Application for a Non-Material Amendment Following a Grant of Planning Permission

Proposed two-storey and a single storey rear extension, replacing an existing single glazed conservatory, along with internal alterations and 2no. first floor front dormers and a ground floor entrance porch.

22/01622/HOU

Drawing No.
 280/PL 07 Rev. C

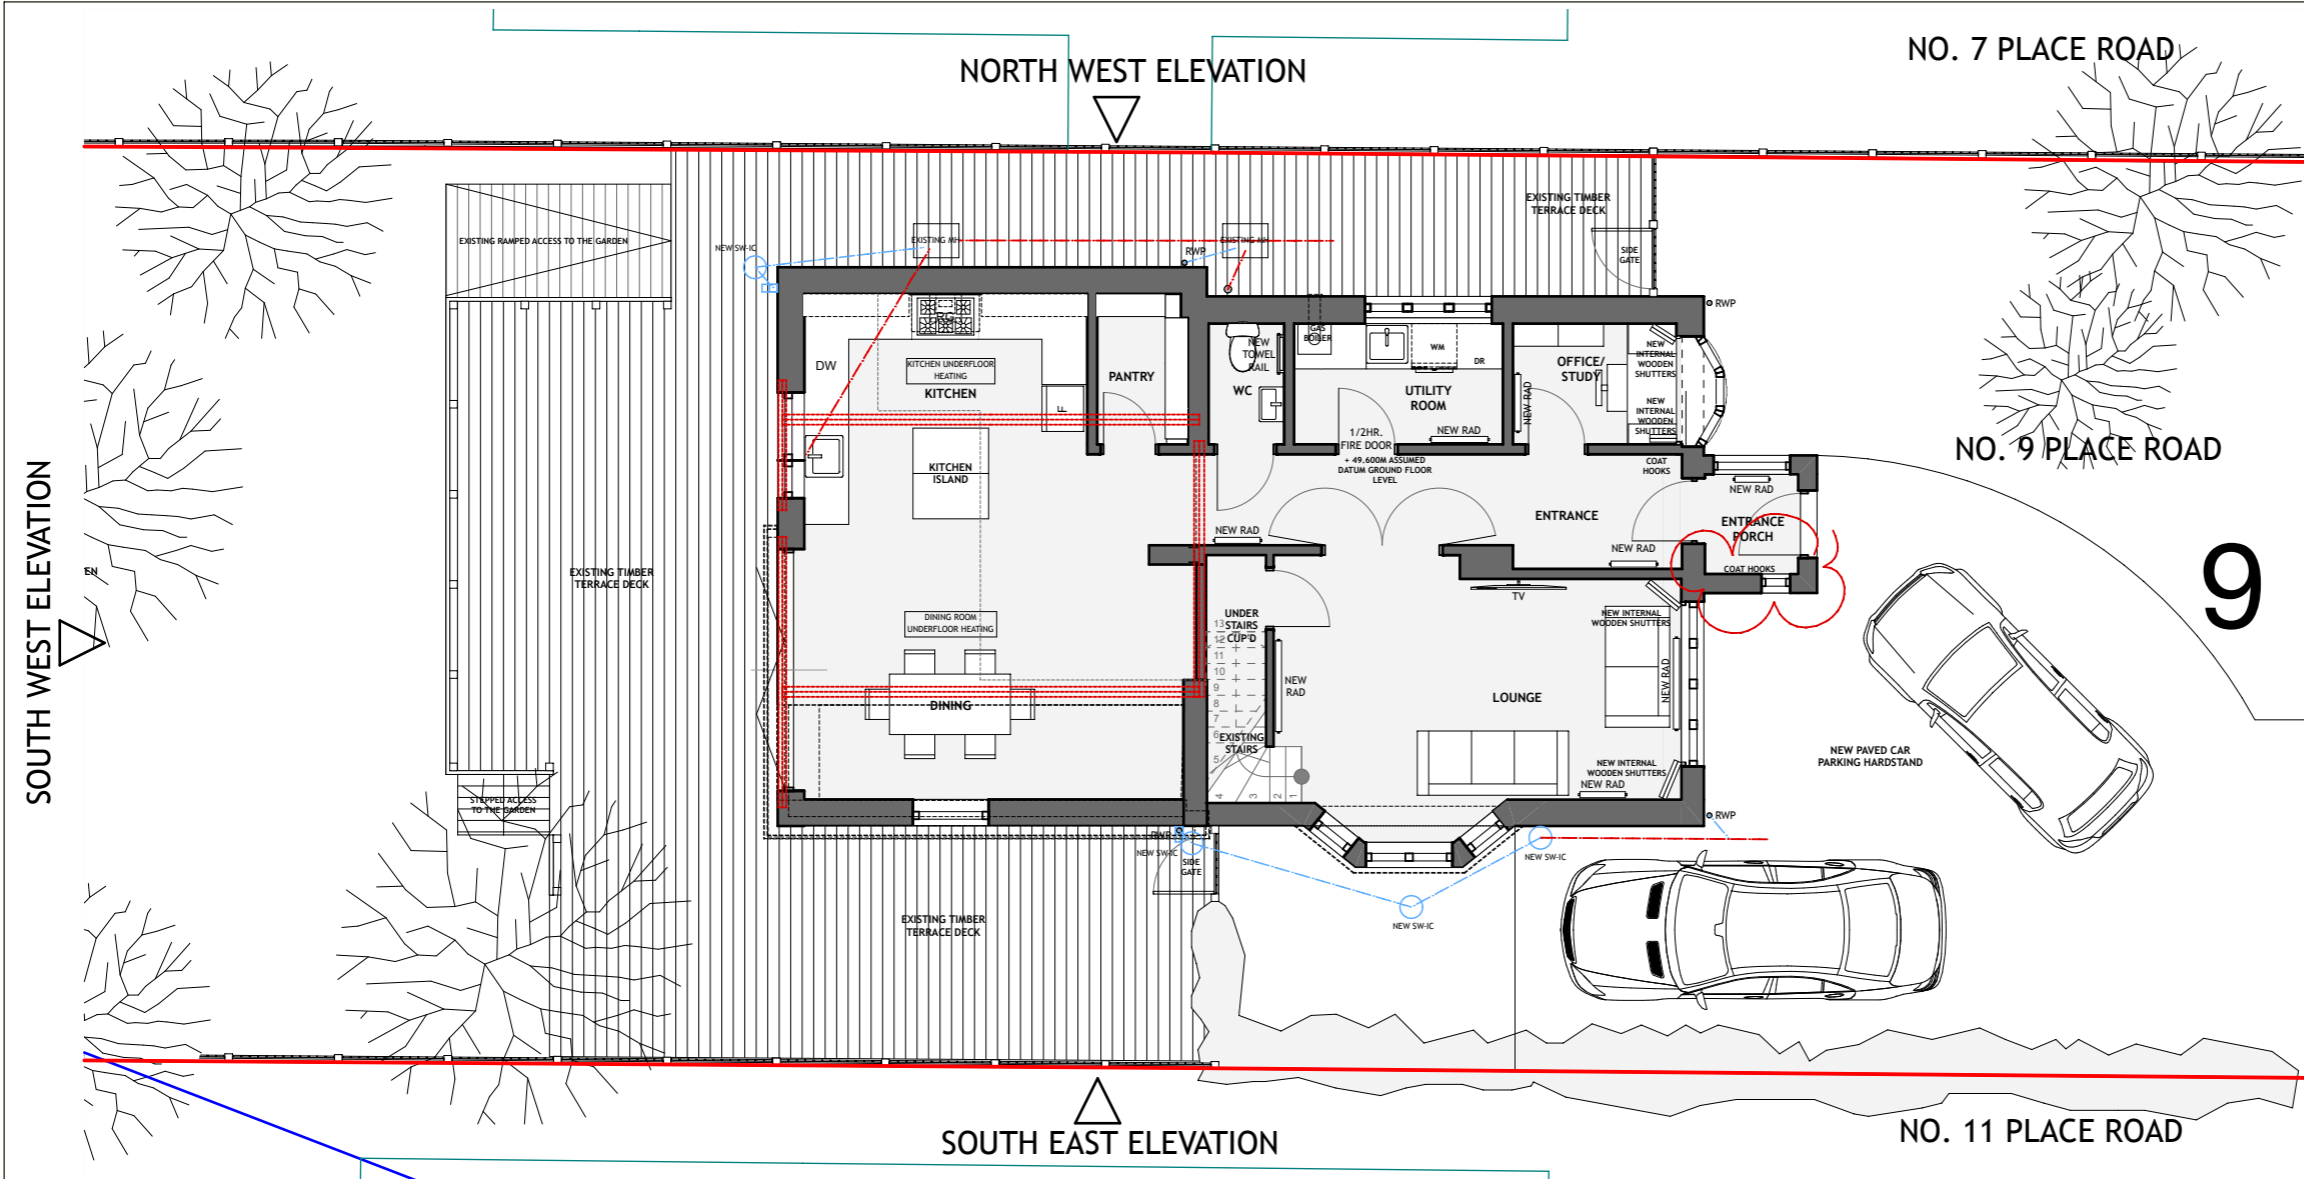
This NMA application is for the front porch is for amending the front porch ground floor right side window from a horizontal slot window to a vertical slot window.

Client would like to see more of the front garden. The front porch is on the ground floor and the window will look towards an existing boundary fence so this change will not affect the privacy of the neighbouring property.
